PLANNING APPLICATION REPORT**REF NO:** BE/34/08/**LOCATION:** 11 Ashurst Close
Bognor Regis**PROPOSAL:** Outline application for single storey dwelling.**SITE AND SURROUNDINGS****DESCRIPTION OF APPLICATION****SITE AREA****RESIDENTIAL DEVELOPMENT
DENSITY (NET)** N/A**TOPOGRAPHY** Predominantly flat**TREES** None of any significance affected by the proposed development.**BOUNDARY TREATMENT****SITE CHARACTERISTICS****CHARACTER OF LOCALITY****RELEVANT SITE HISTORY**

Title
Proposed new property
in garden to side of
11 Ashurst Close
North Bersted
Bognor Regis
PO21 5UJ

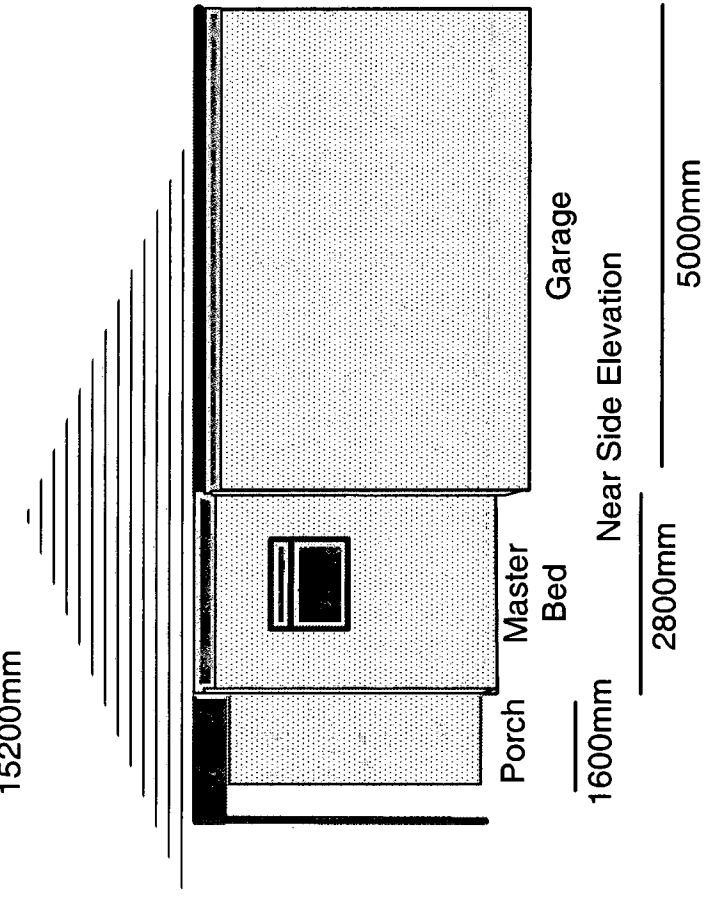
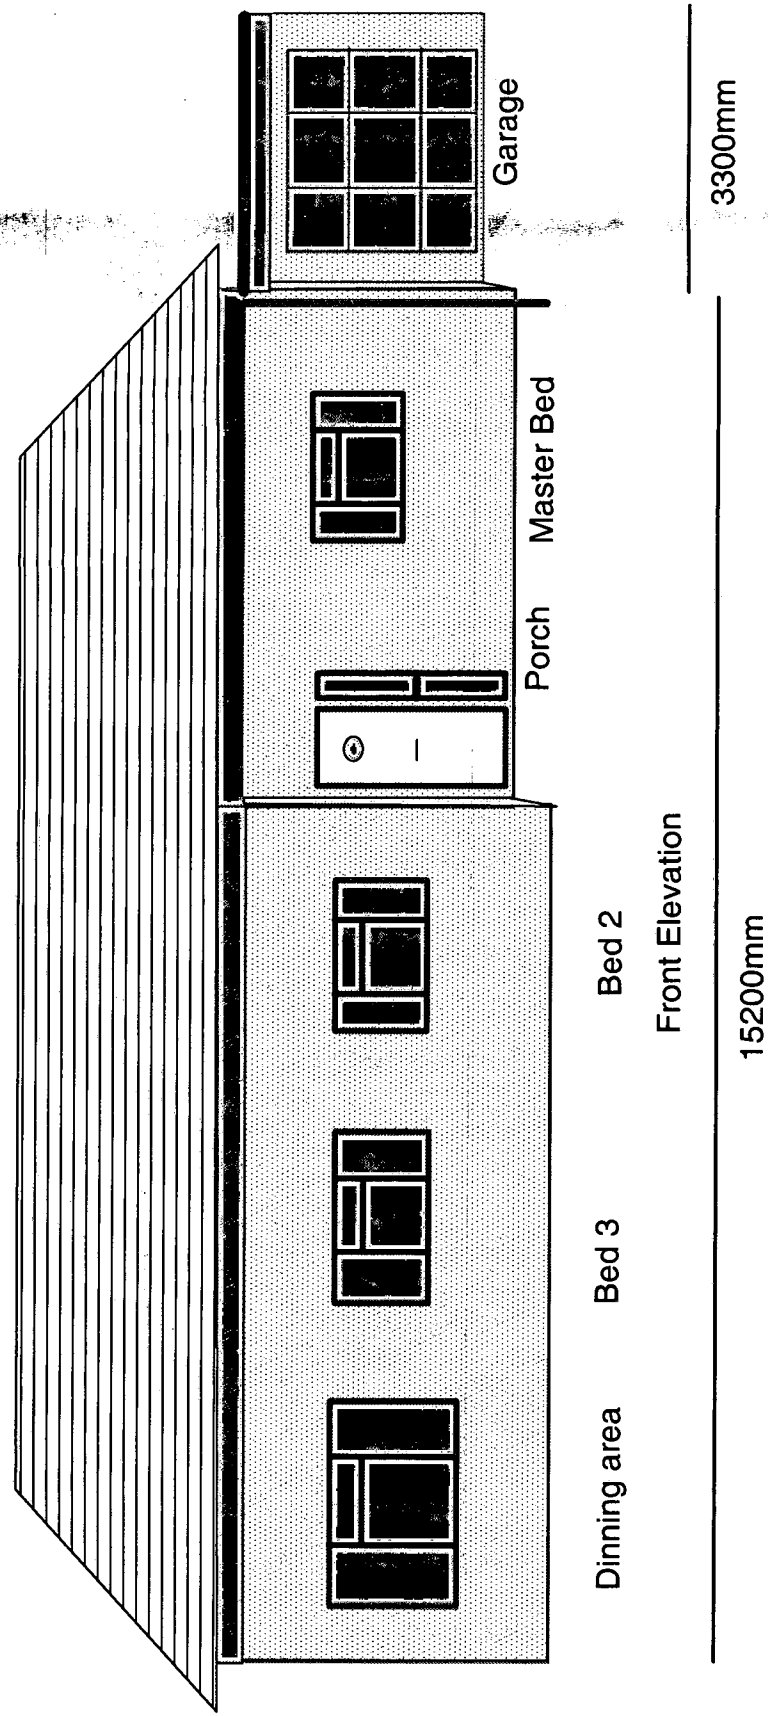
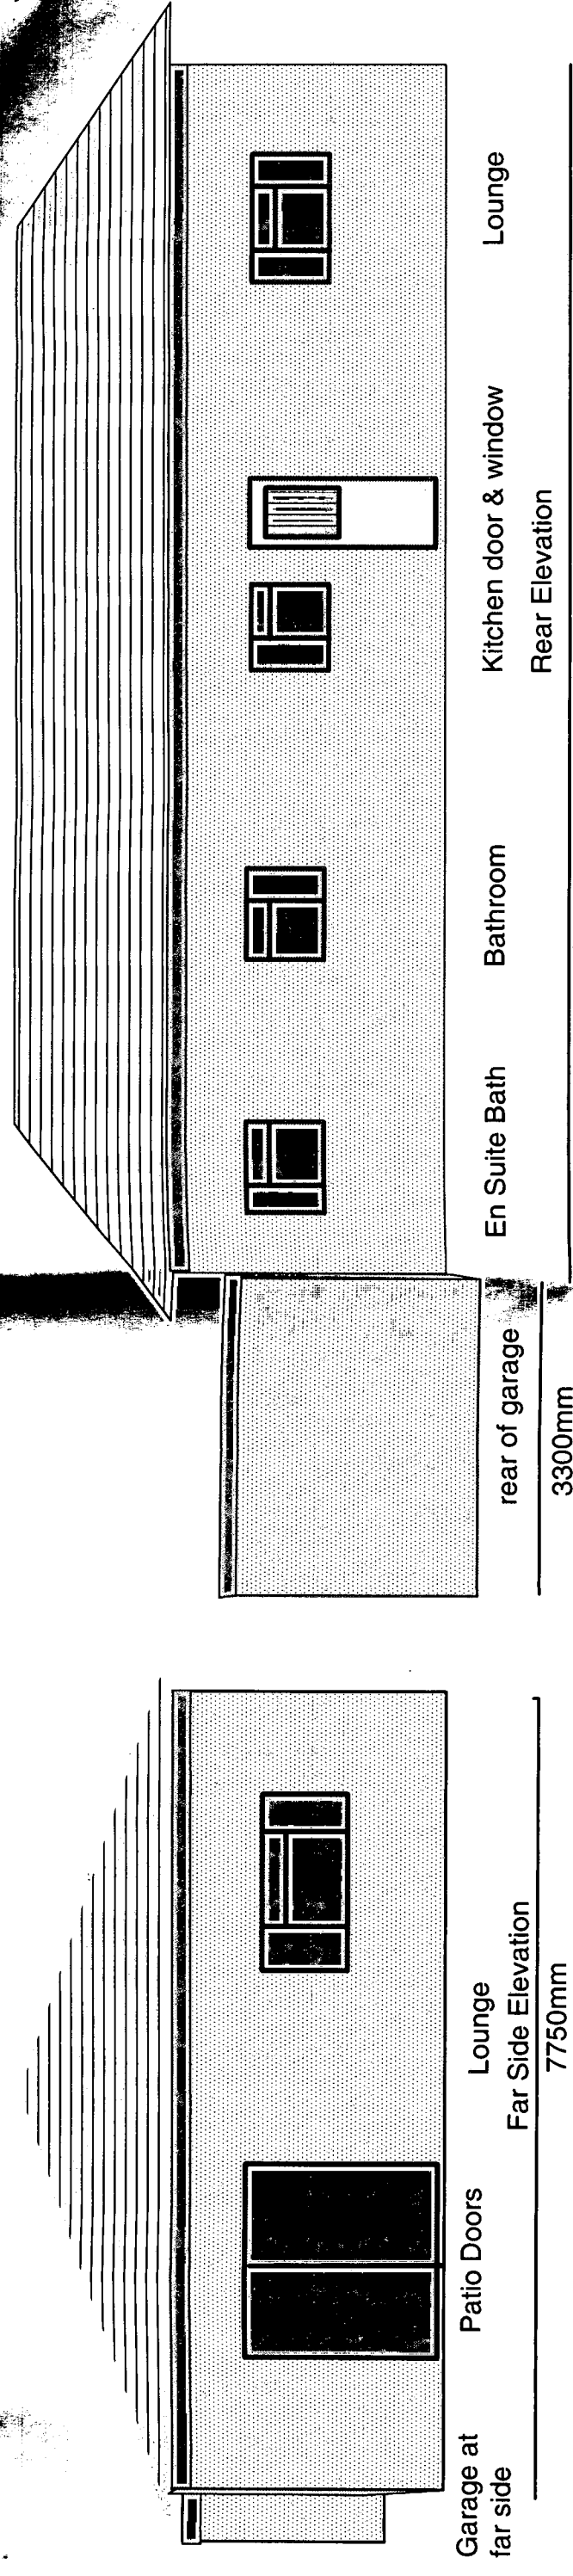
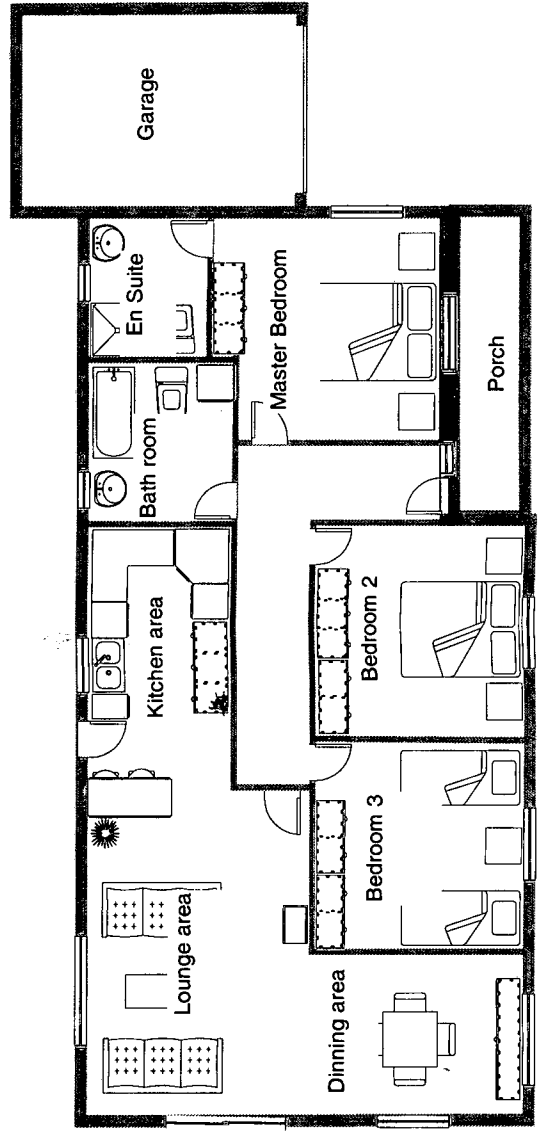
- 1 The development of this site by the erection of a bungalow in the position proposed and of the size indicated would be out of keeping and prominent in the street scene and would adversely affect the character and appearance of the locality in conflict with policies DEV1, CH1 of the West Sussex Structure Plan and GEN7 of the Arun District Local Plan.
